Application No: AW/151/20/PL
Site Address: 17 Nyewood Lane Aldwick PO21 2QB
Description of works: Change of use of former residential parenting unit (C2 Residential Institution) to 9 bed House in Multiple Occupation (Sui Generis). .

Planning Application AW/151/20/PL
House in Multiple Occupation - 17 Nyewood Lane, Aldwick

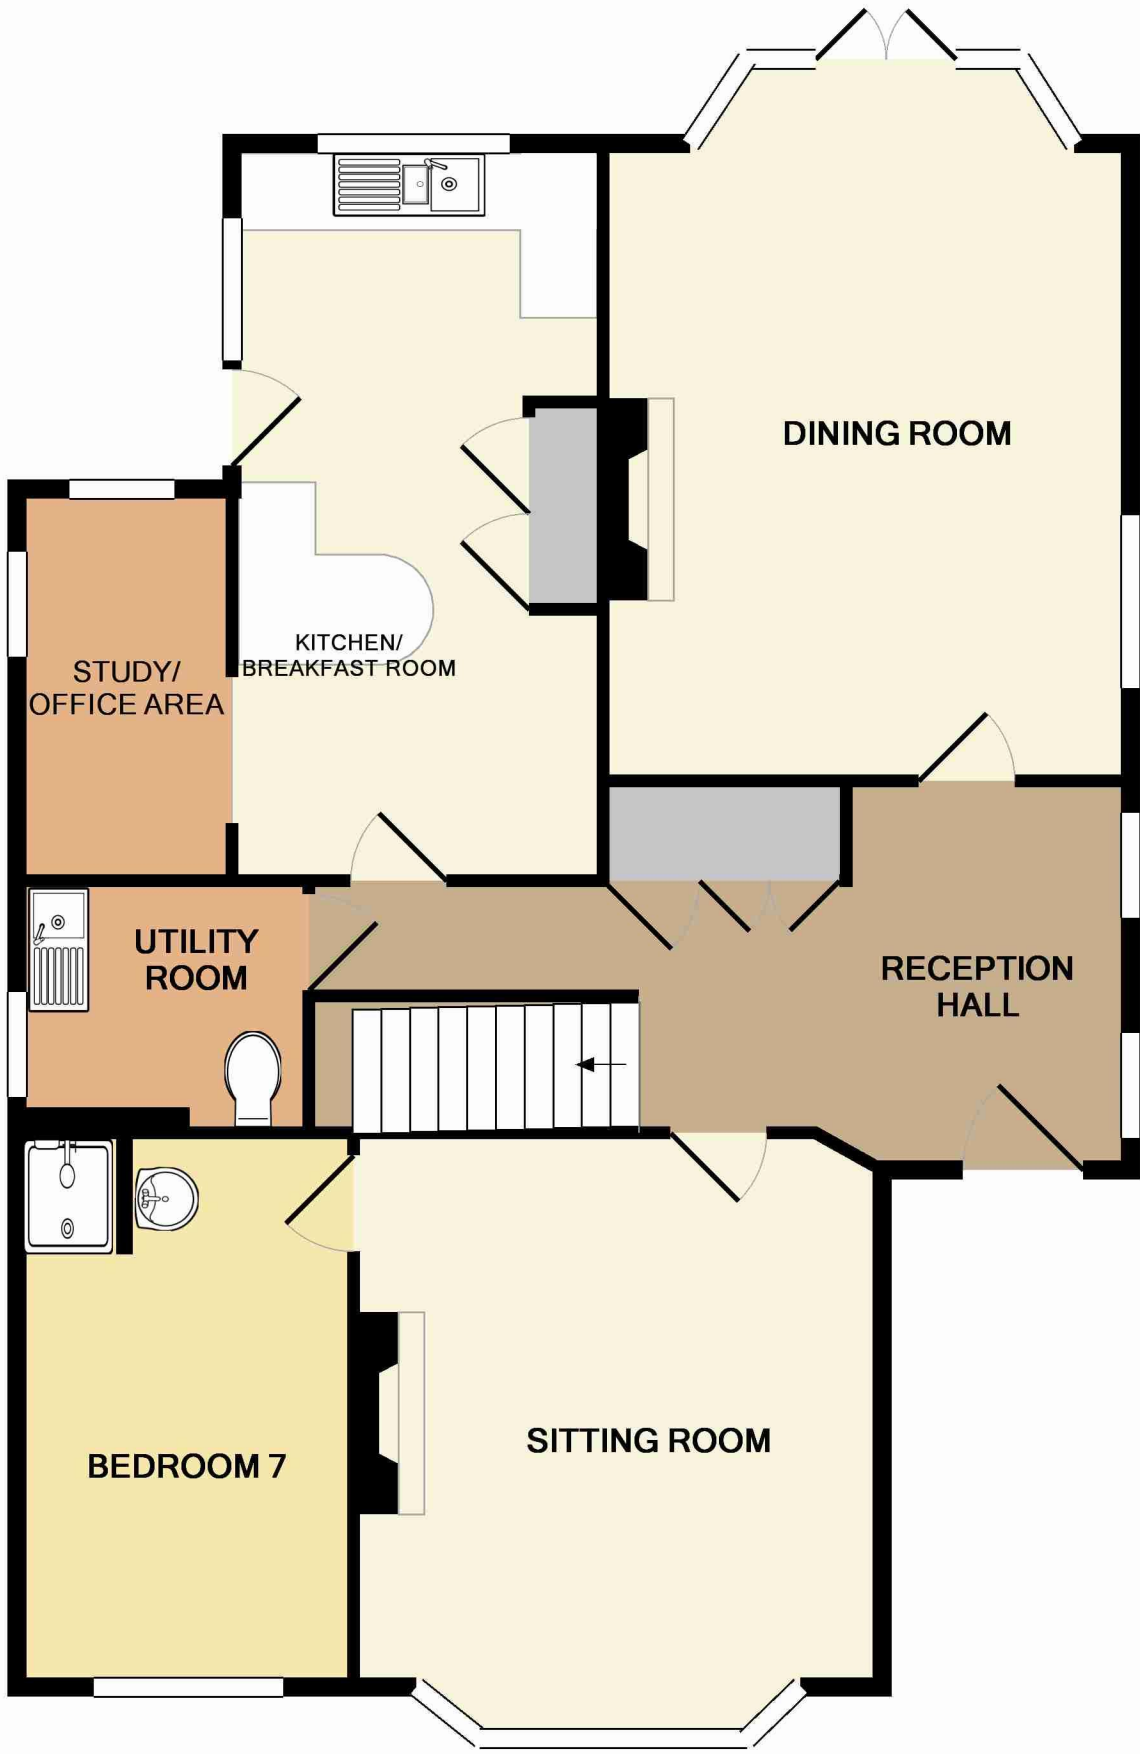
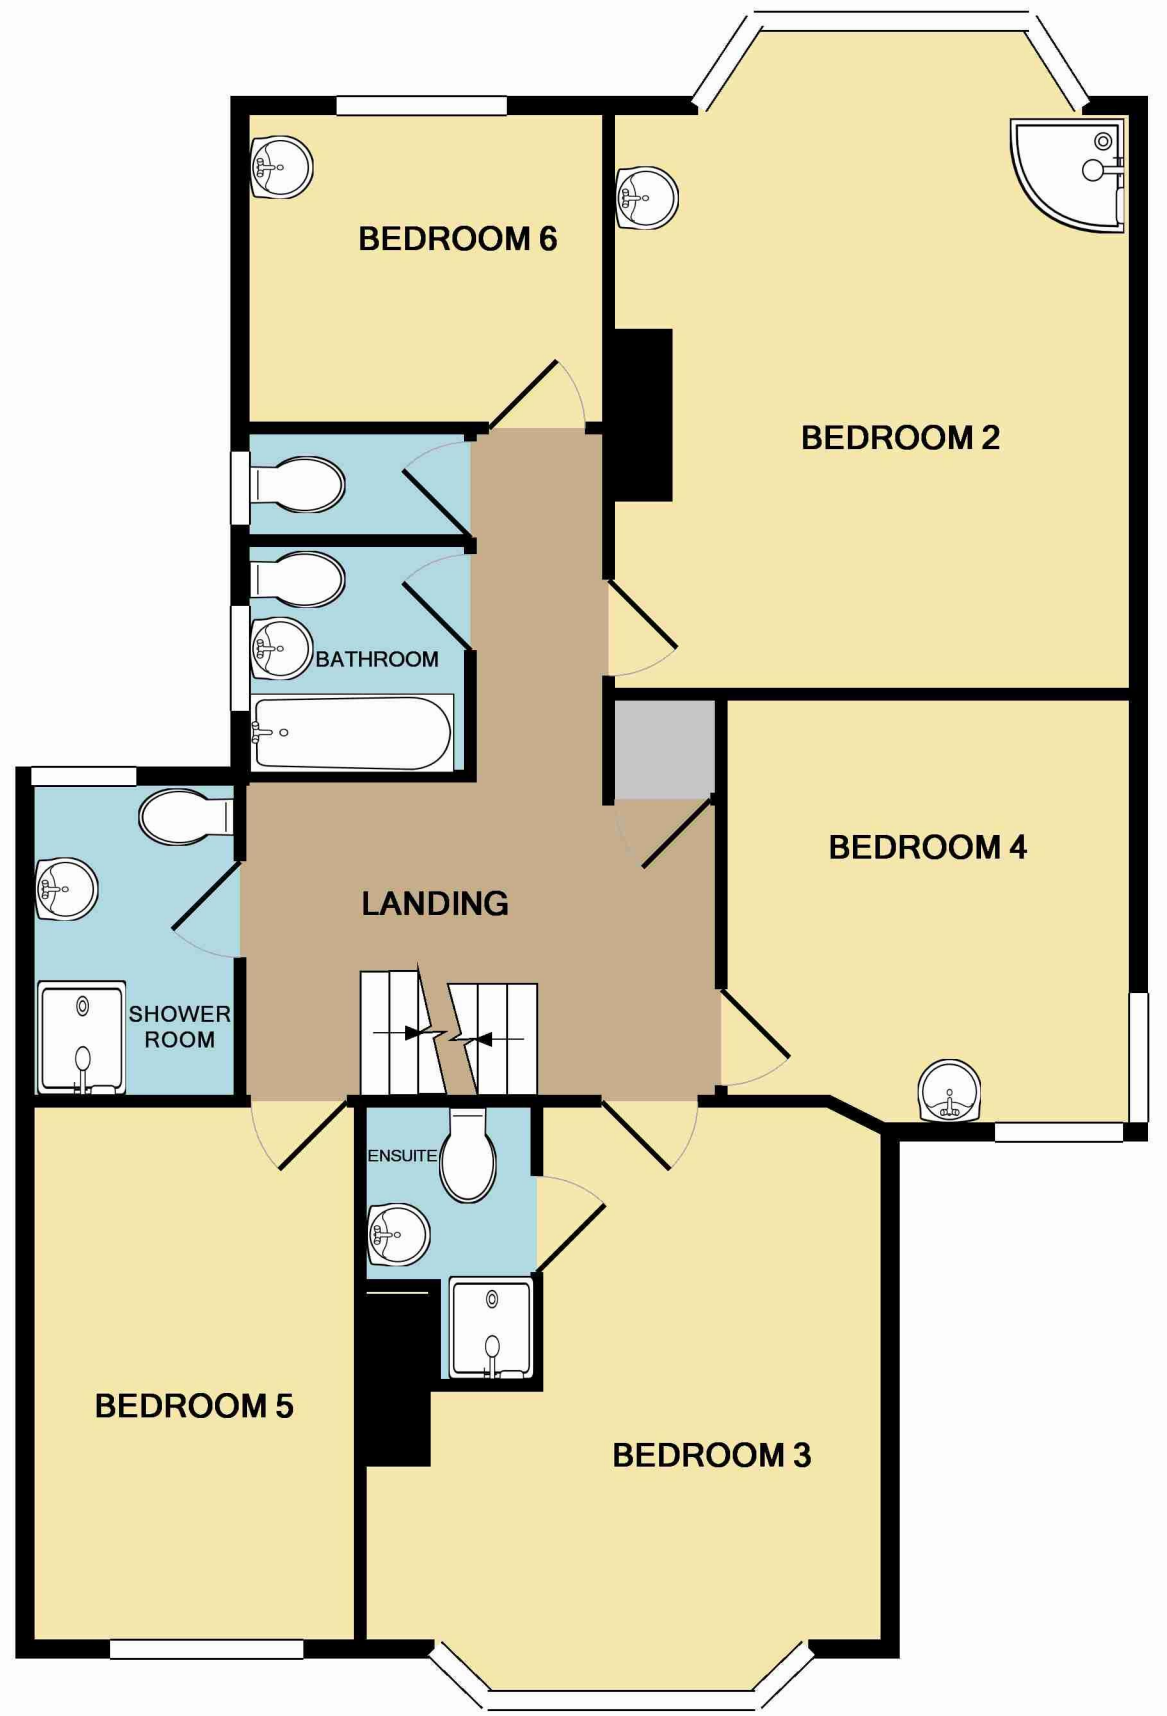
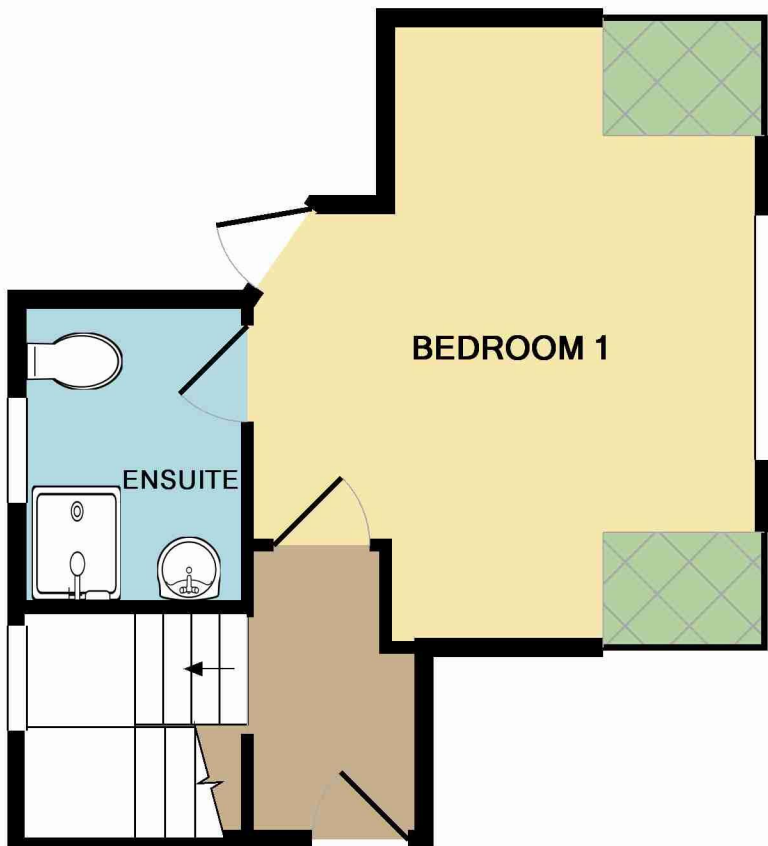
1. 17 Nyewood Lane is a small house on a very small plot. The proposal is for nine bedrooms of which eight will be served by only one bathroom; one utility room, and a small kitchen/dining area.

3. The plans do not show any fire escape other than the internal staircase (wooden?). Any external fire

escape would have to be at the rear of the property and be intrusive for the properties along Wessex Avenue

ORIGINAL
☐ = POSITION OF
RUBBISH AND
RECYCLING BINS

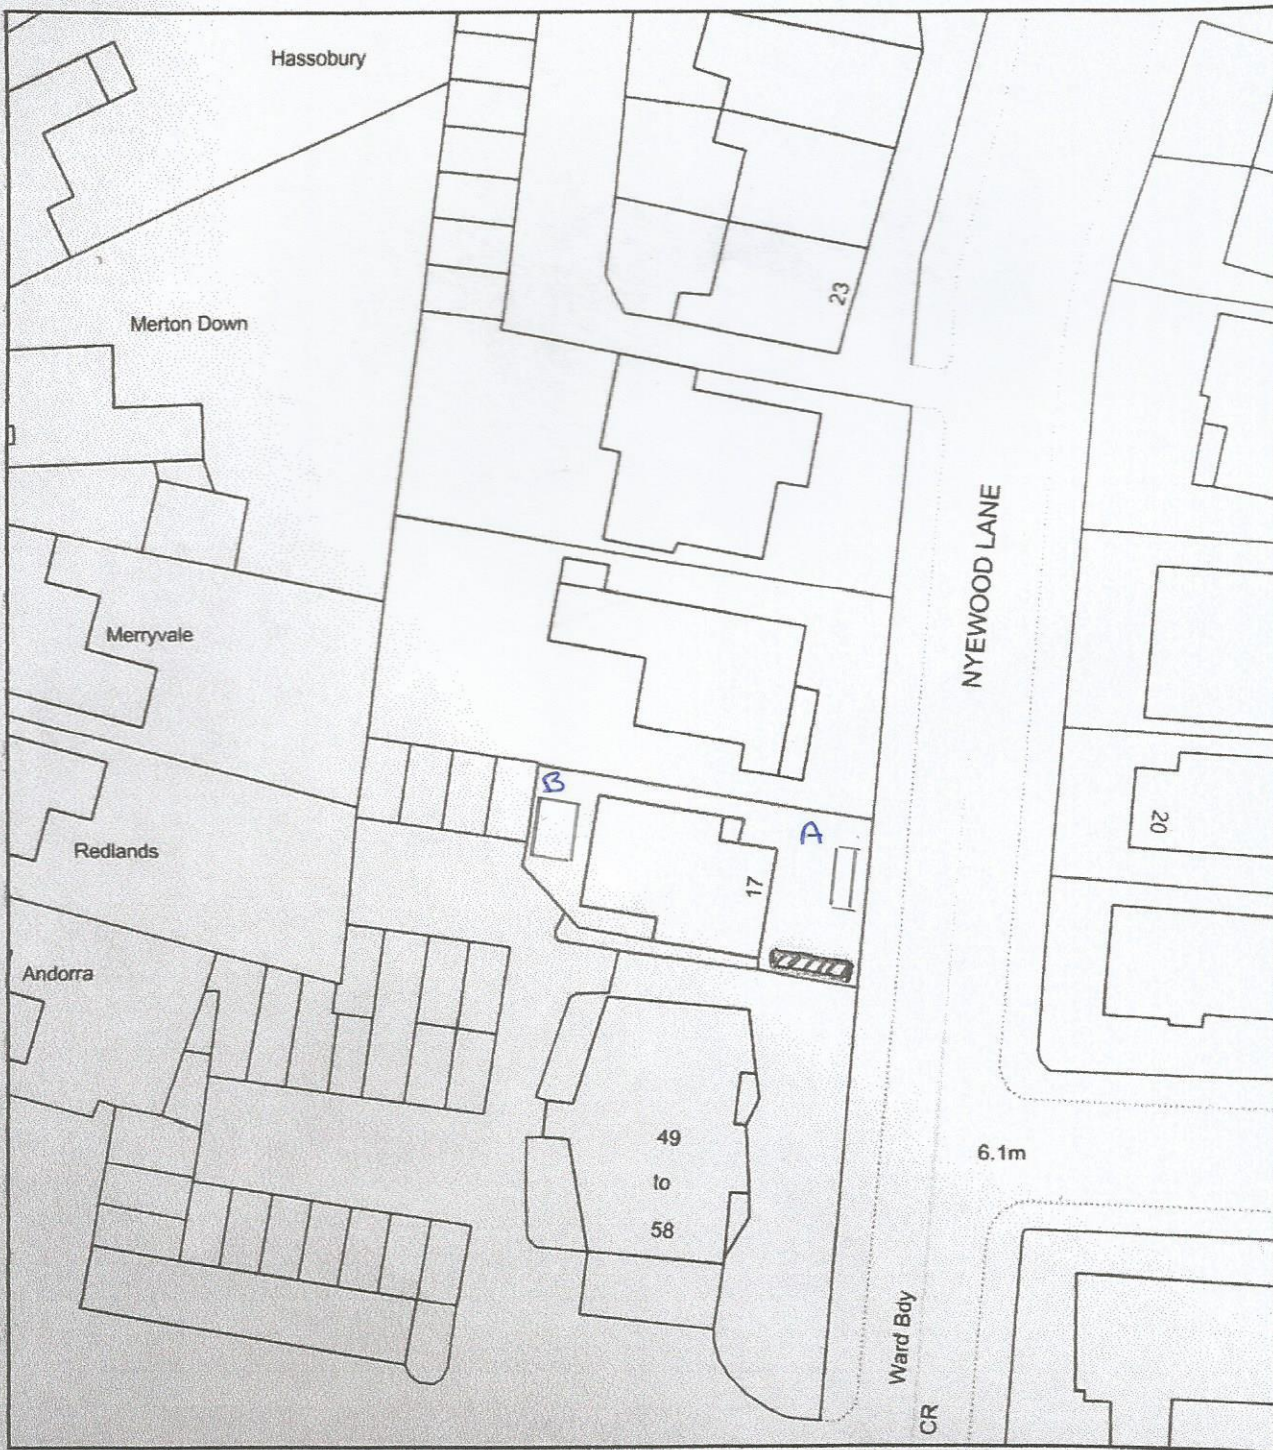
2. The proposal allows for three car parking spaces (in addition to refuse bin storage) at the front. This will result in the loss of one on-street parking bay. The consequence will be increased pressure on on-street car parking. Stocker Road is effectively parked up on both sides almost permanently. The roads behind the site (Wessex, Princess and Selsey Avenue) become fully parked by staff from local businesses and overflow parking from the Marine Park flats. Inevitably parking will become more contentious.
